**Consultation Response from KC,
Trees**
2024/93221 Parkwood Mill, Stoney Lane, Longwood, HD3 4ZQ
Erection of 5 dwellings and associated works (within a Conservation Area)
Date Responded: 08/07/2025
Responding Officer: Hazel Irving
Responding Ref: 04/98

**PROPOSED SITE PLAN**  
SCALE 1:200

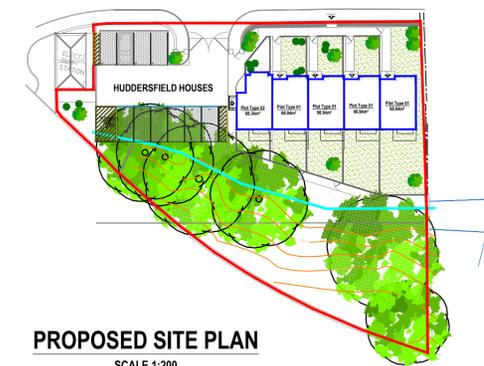
Previous comments regarding the significant shadow cast by the protected trees on the southern boundary have been addressed by moving the proposed dwellings slightly northward. However, realistically this amendment will not significantly reduce the shading in the rear gardens, which would still be almost perpetually cast in shadow.

As previously stated, future residents of the proposed dwellings are unlikely to tolerate the presence of the protected trees overhanging the rear gardens, nor the nuisance of shedding branches or falling leaves. Additionally, as the trees are located to the south of the proposed dwellings, and the future residents may not tolerate the shade cast by the canopies, which cast all the rear gardens into shadow and extends almost completely over the entire row buildings. These conflicts would place pruning pressure on the TPO'd trees, and they may also be pressure to remove them entirely.

Unfortunately, there remains an objection from an arboricultural perspective, as they conflict with Kirklees Council Local Plan Policy 33 and 24(i).
